## TRINITY HOUSE

Your Ref: **EN010109**  
Identification No. **20032913**

**The Sheringham Shoal Offshore Wind Farm Extension and Dudgeon Offshore Wind  
Farm Extension Projects  
Written Submission in respect of the Examining  
Authority's Third Written Questions (WQ3)  
for Deadline 5**

Sheet 1 of 6

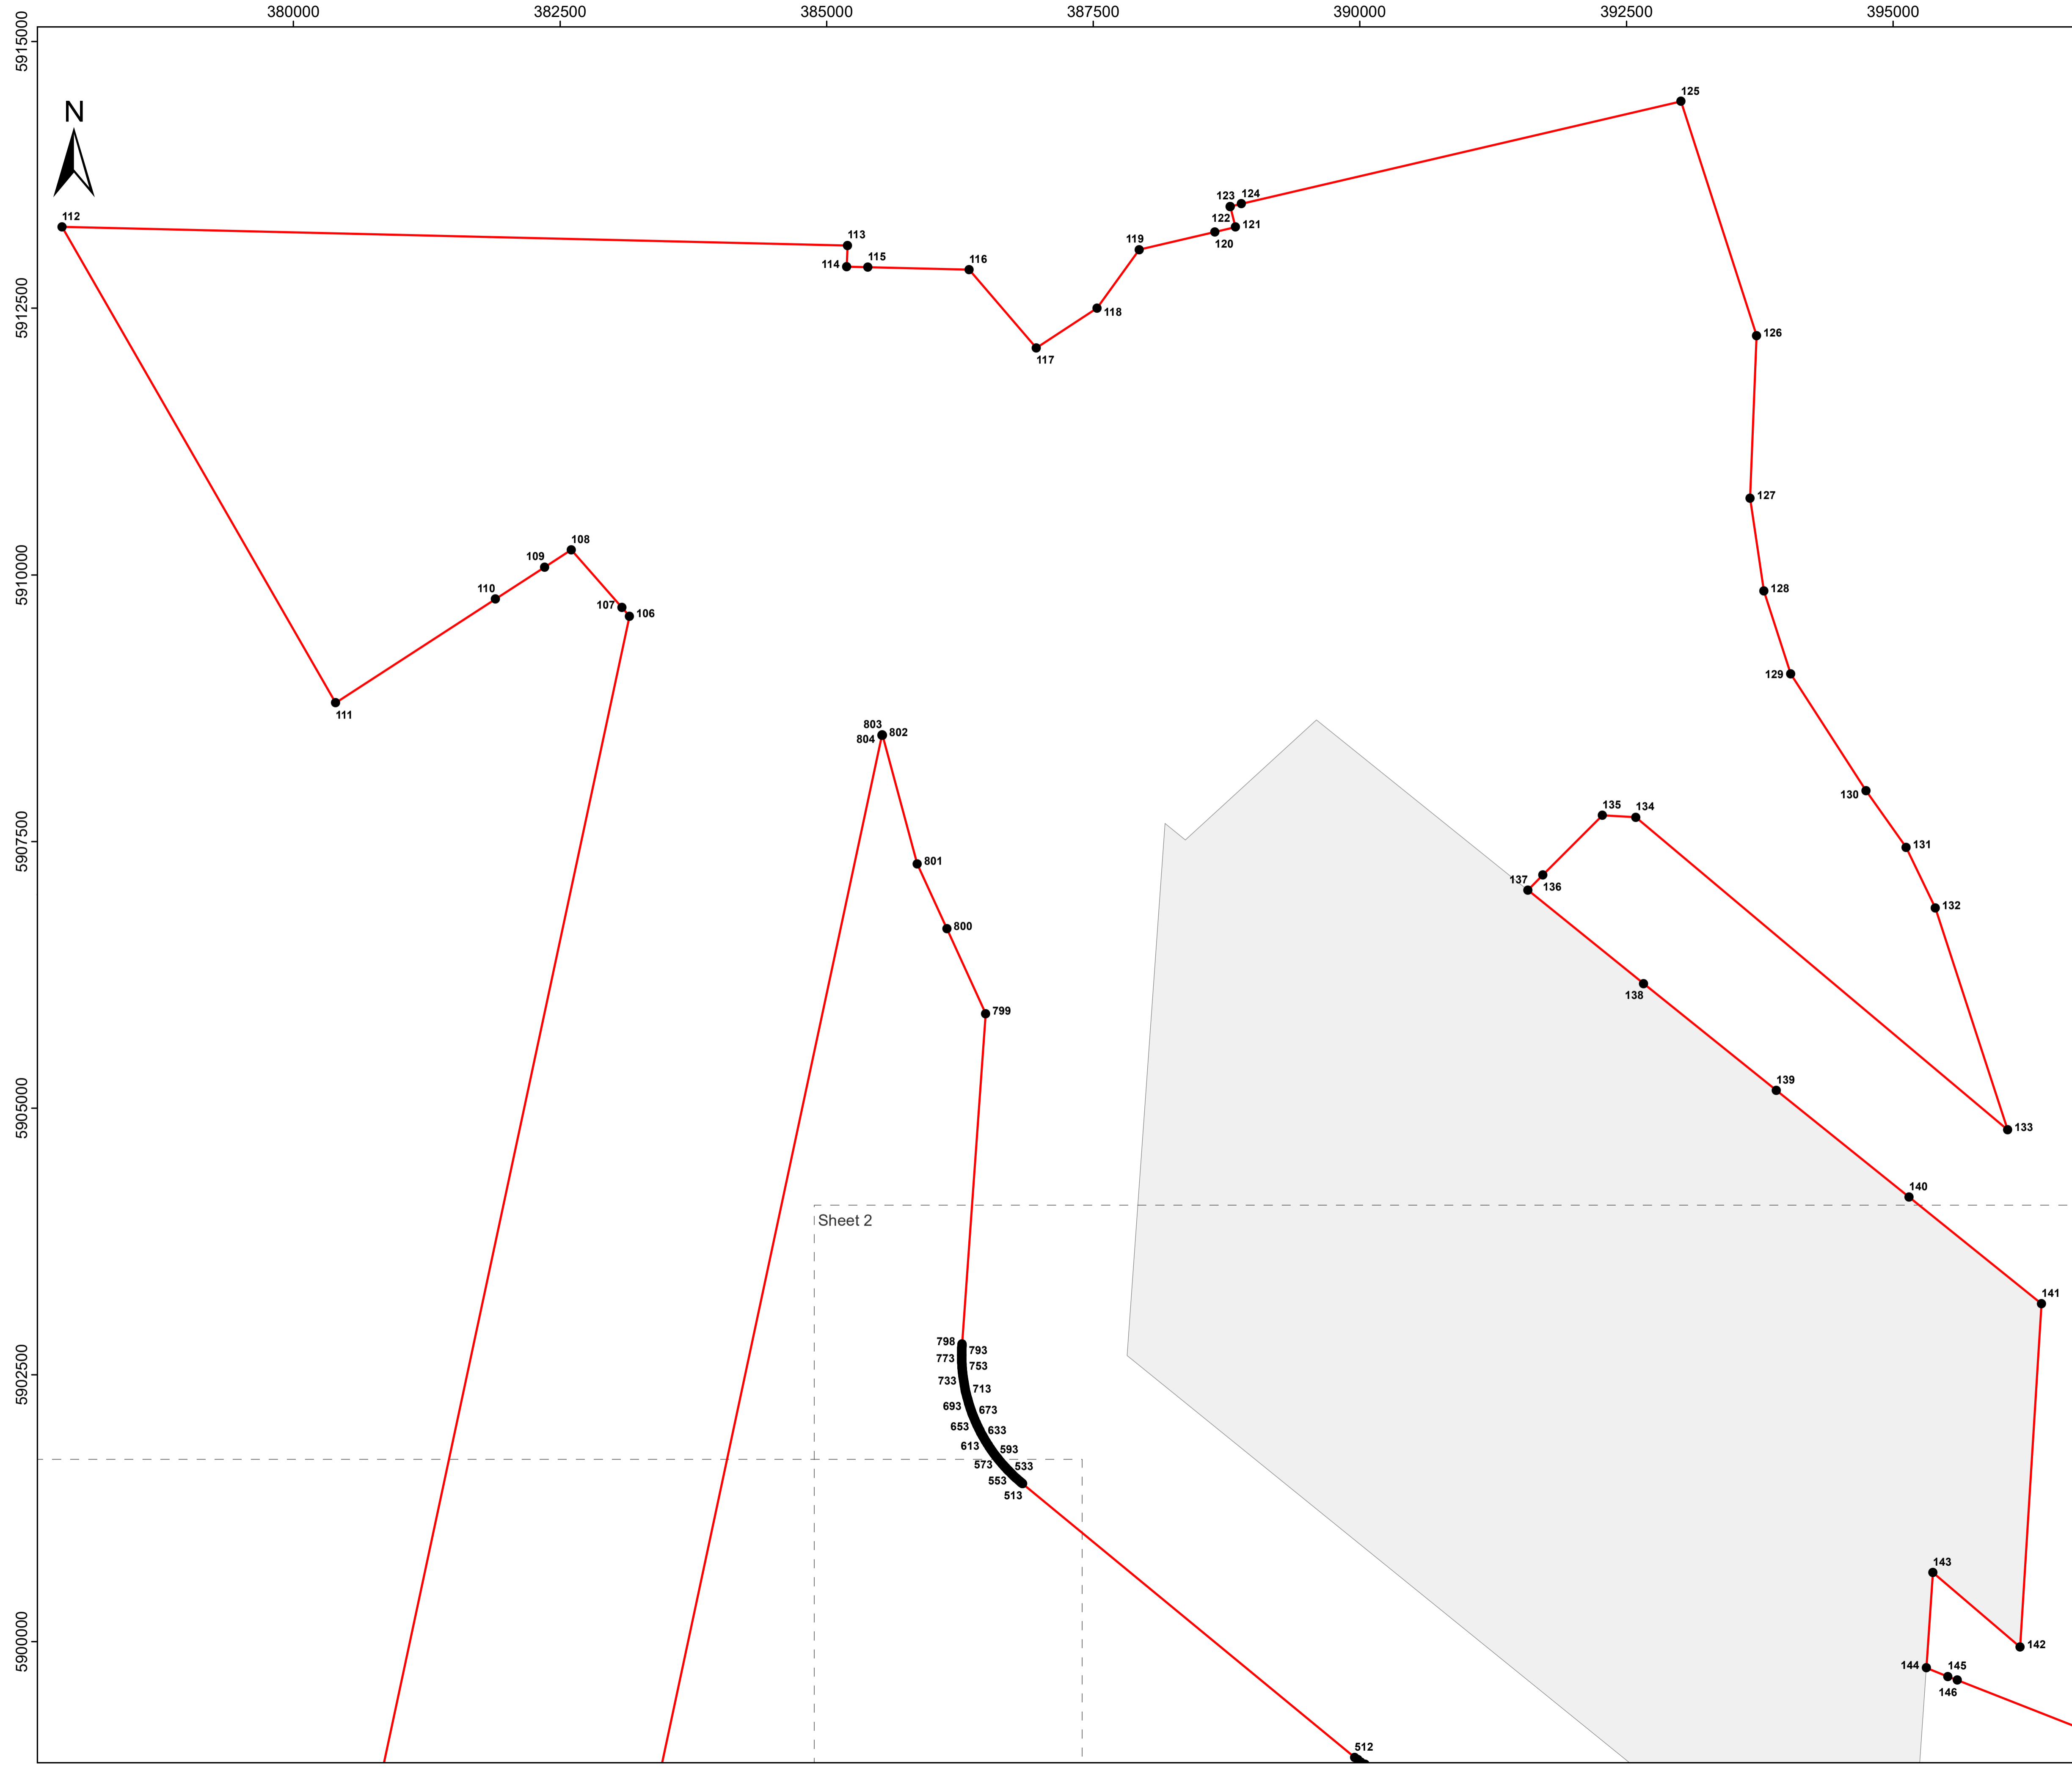
When viewed alongside the existing buoy to buoy line which marks the extremities of the current shipping route (figure 5), the proposed boundary of the windfarm encroaches into the shipping route by around 0.84nm. As a percentage of the existing Outer Dowsing channel this is approximately a 22% reduction in available sea space.

However when viewed with the current traffic pattern (figure 6) the proposed boundary goes right up to the current limits of the shipping. If shipping routes were to be adjusted to stay 1.0nm clear of the windfarm this would reduce the usable sea space by around 50%.

As can be seen from Figure 6 this does present an enhanced risk of collision by compressing the traffic into a channel which could be approximately only 2 miles wide when passing the end of the Triton Knoll. Vessels are currently allowing a safe passing distance of 1nm from the bank so it could be argued the effective sea space is now only about 1nm. If consideration is then given to fishing activity in the area, and to additional vessels servicing the windfarm, then the enhanced risk of collision could become significant.

5. The area at the DEP north west boundary is the area of greatest concern as the reduction in sea space could possibly lead to grounding on the Triton Knoll for some vessels and this would need mitigating if the project is consented and builds out to the red line.

-  90th percentile with 1nm clearance from DEP North
-  90th Percentile (Tees- Zeebrugge)
-  DEP & SEP Extensions

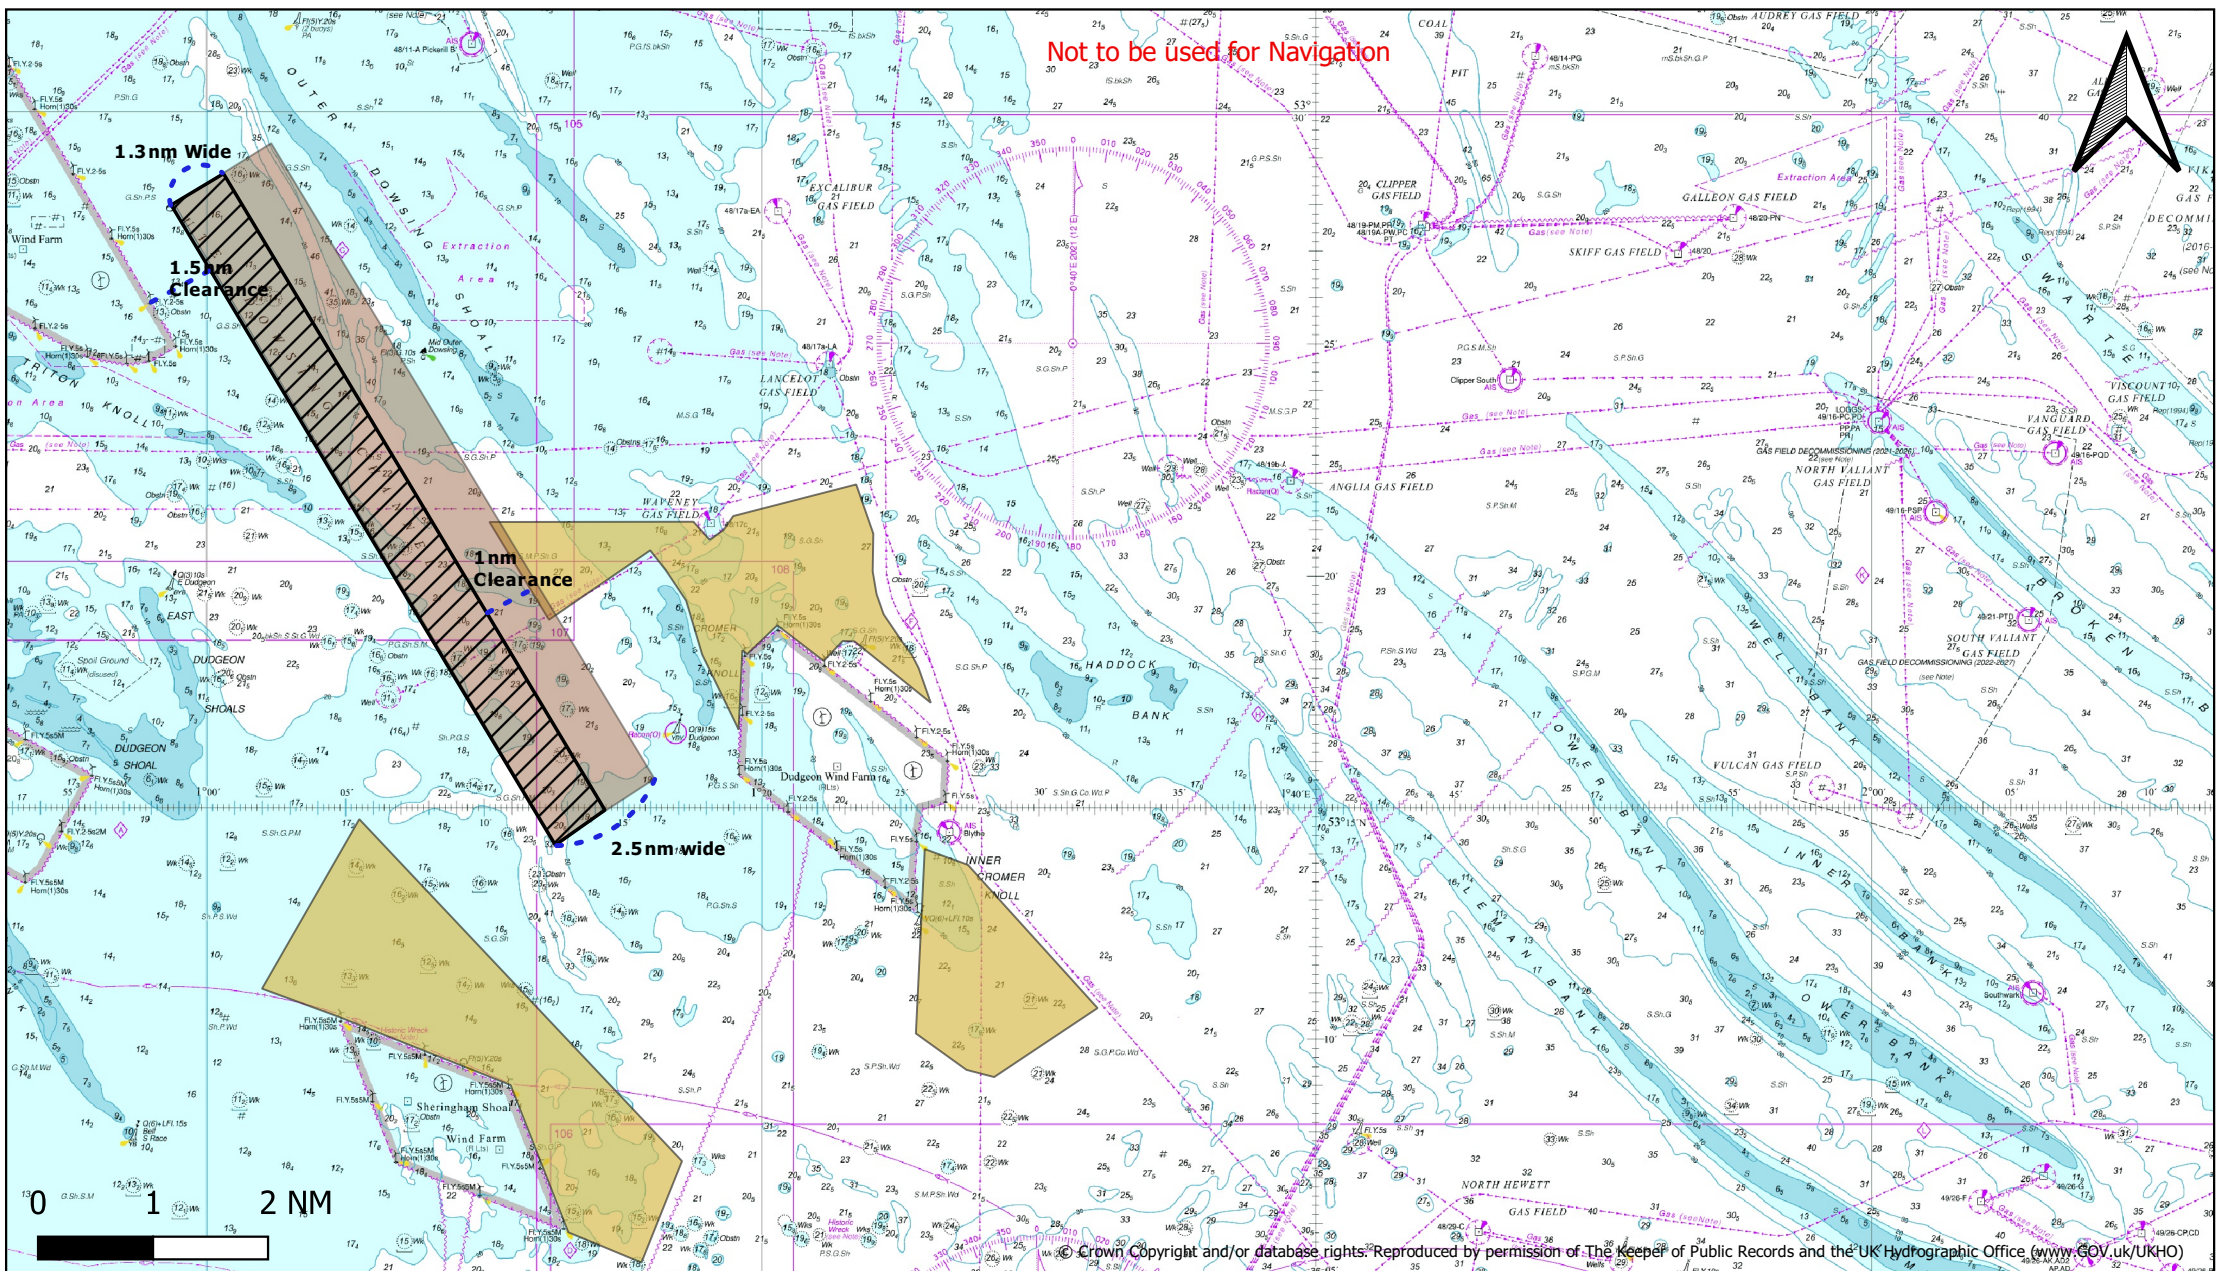
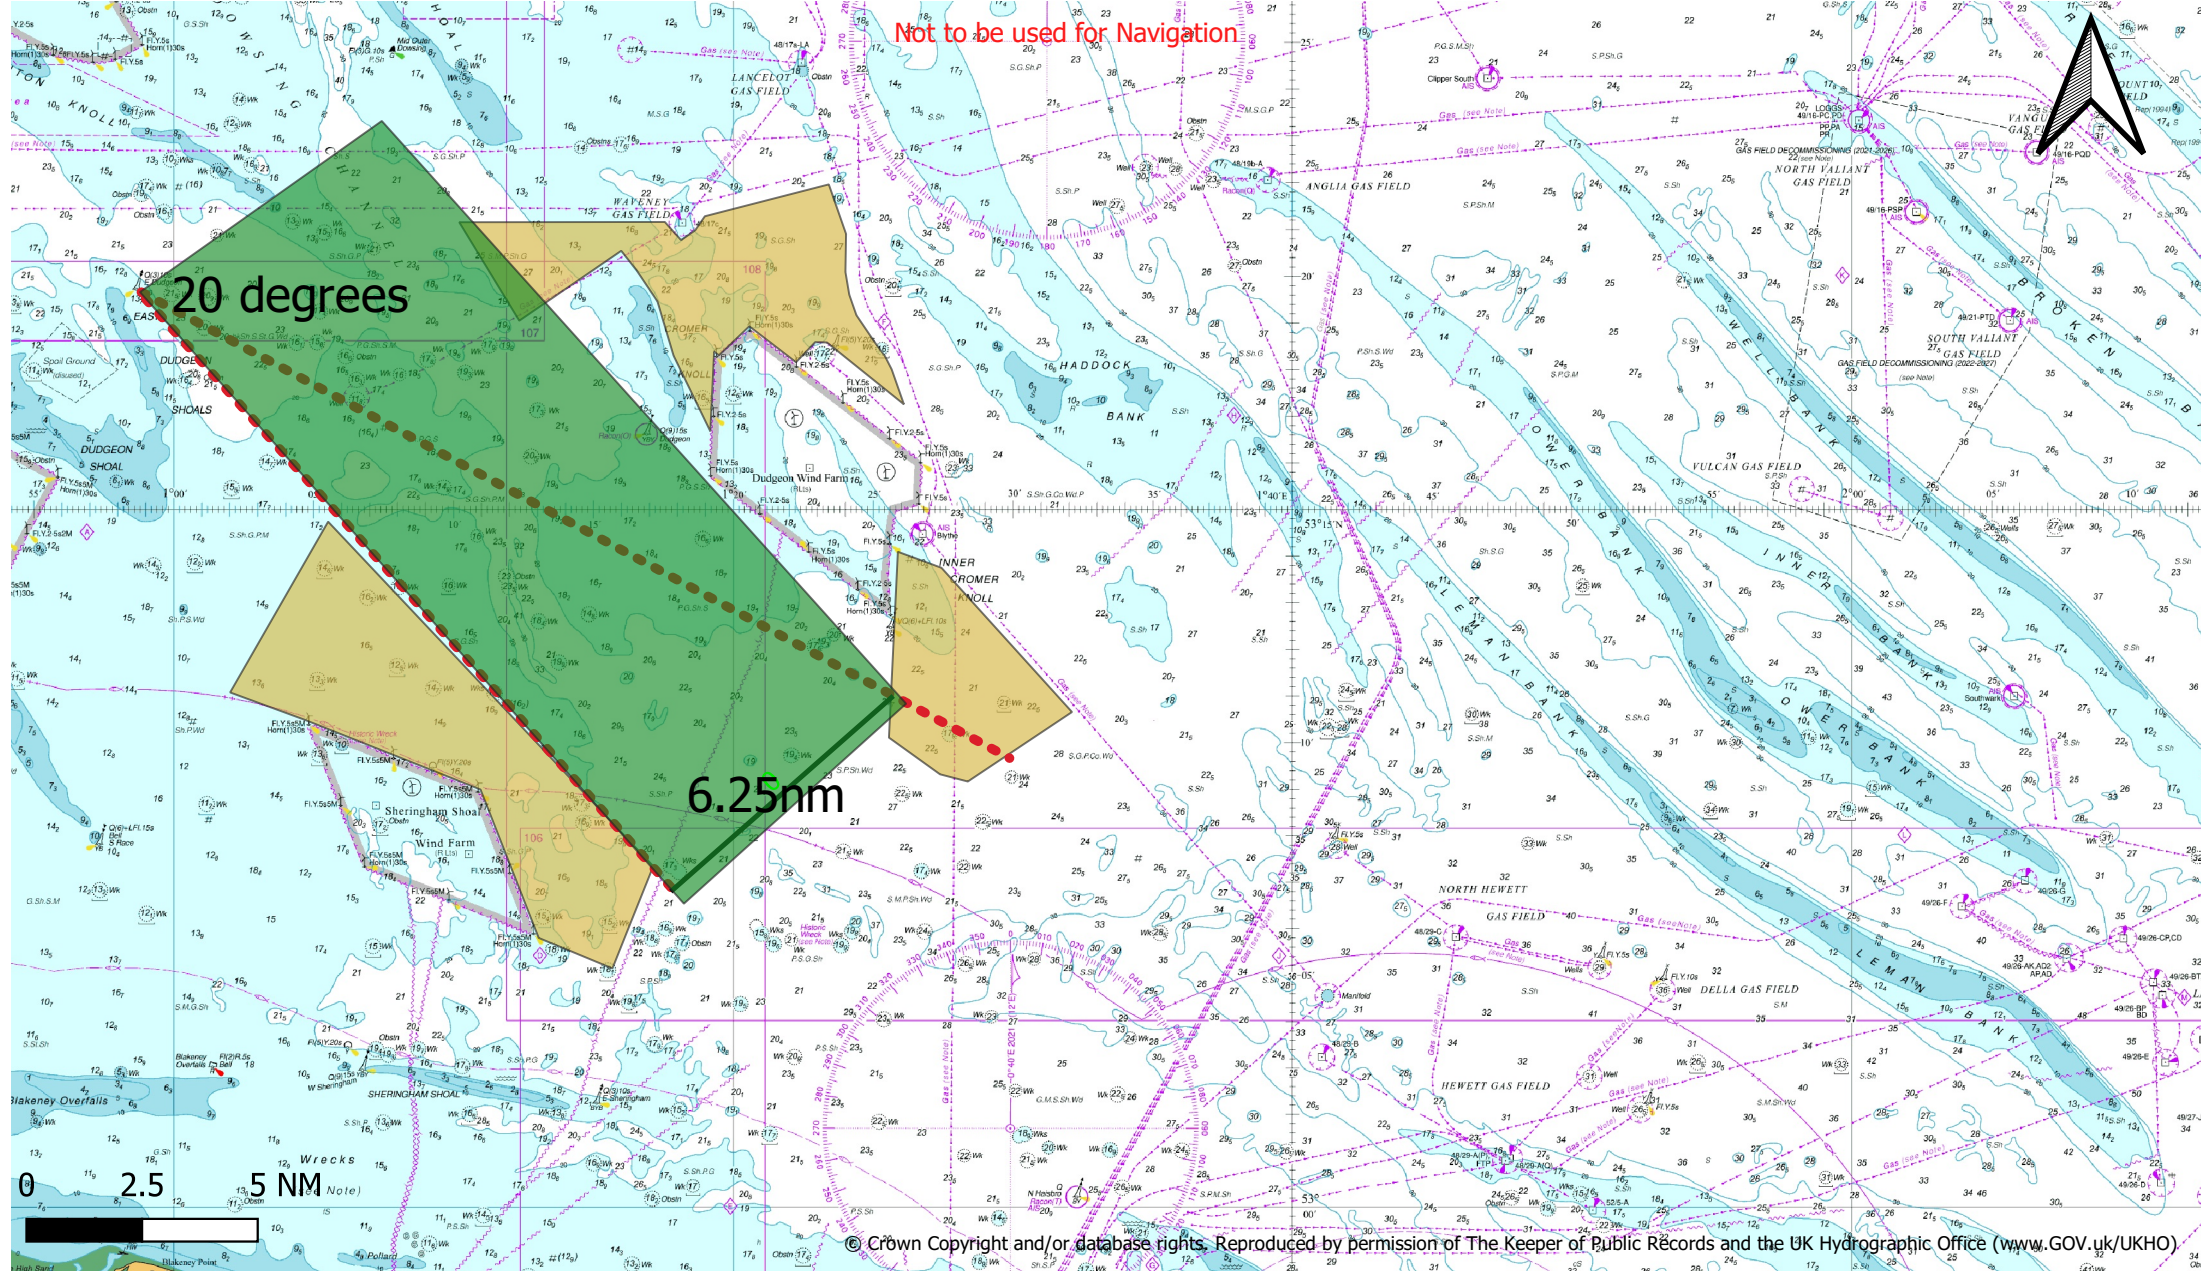
The MCA's position that the corridor should be measured up to the East Dudgeon Buoy [REP1-117], instead of to the end of the proposed Sheringham Extension, could be the preferred solution when assessing the compression of the traffic given the DEP North Westerly boundary encroaches on the shipping lane. However, in this instance, as can be seen in figures 2 and 3, the traffic appears to already have moved to the sides of the available sea room to progress up the Outer Dowsing Channel or west of Triton Knoll windfarm. Trinity House would suggest that the additional length of the channel when considered in calculations would not bring additional mitigation to this area.
